**Marge Schmuckal - Permit application 2013-01960 - 129-B-8**

**From:** Marge Schmuckal  
**To:** bella1skin@gmail.com  
**Date:** 9/11/2013 11:16 AM  
**Subject:** Permit application 2013-01960 - 129-B-8

CROSS SECTION A-A
EXISTING STRUCTURE

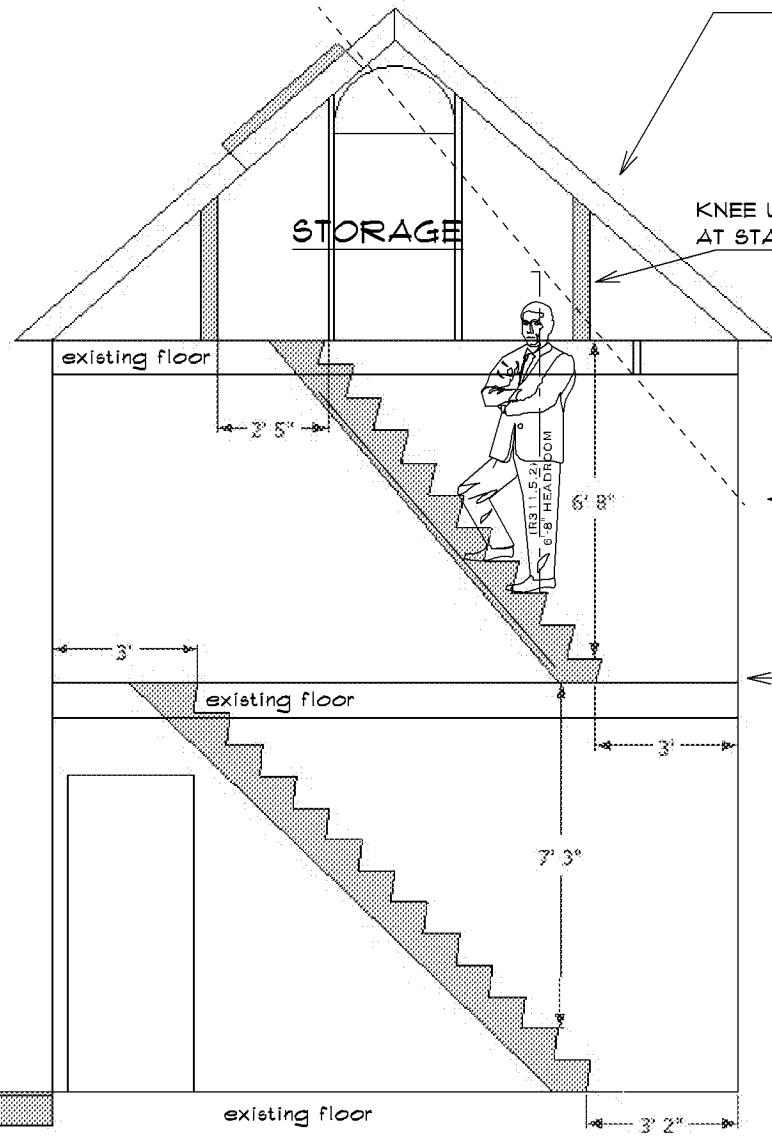
I am also uncertain about the rest of the proposed work. Is the roof line being raised? Please provide a little more information concerning the scope of the work being proposed.
